**App no: 21.1227**

**Address: 21 Chatburn Avenue Clitheroe**

**Proposal: Demolish existing garage. Build new garage with a bedroom annexe above the garage, dormer window to the rear and 2 skylights at the front. (Annex suitable for senior family members)**

Proposed Ground Floor Plan

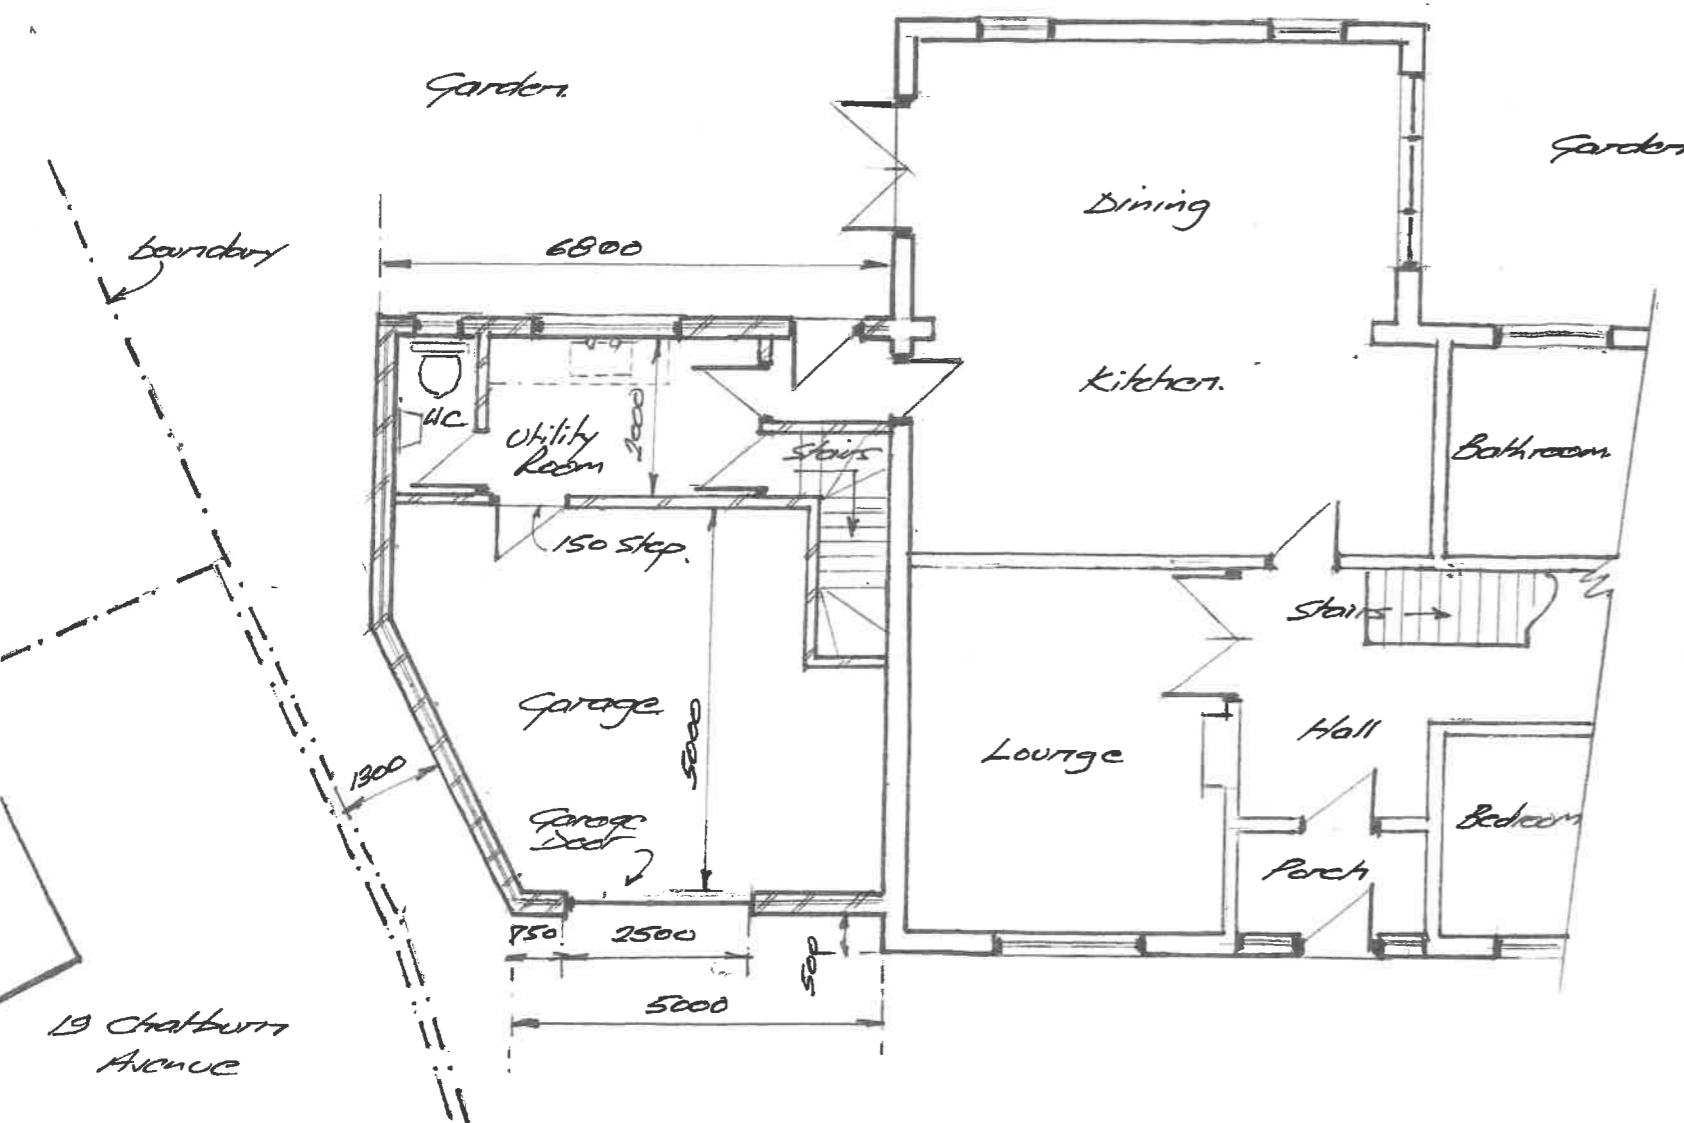
Lancashire County Council acting as the Highway Authority has concerns about this proposal and requests a parking plan and widening of the driveway opening to provide three side by side spaces.

There are currently 3 driveway spaces at the dwelling plus a garage. The proposal retains a single garage but results in a reduction in the driveway spaces to 2 which cannot be used independently due to the single vehicle width opening. This is a concern for a 4+ bedroom dwelling and proposed 1 bedroom annex.

The dwelling is located within the turning head of Chatburn Avenue and therefore any overspill parking is likely to result in obstruction for turning vehicles and the neighbouring driveways. This is a highway safety concern.

There is potential to widen the driveway opening to 7.2m to allow three driveway spaces to be used independently and more practically.
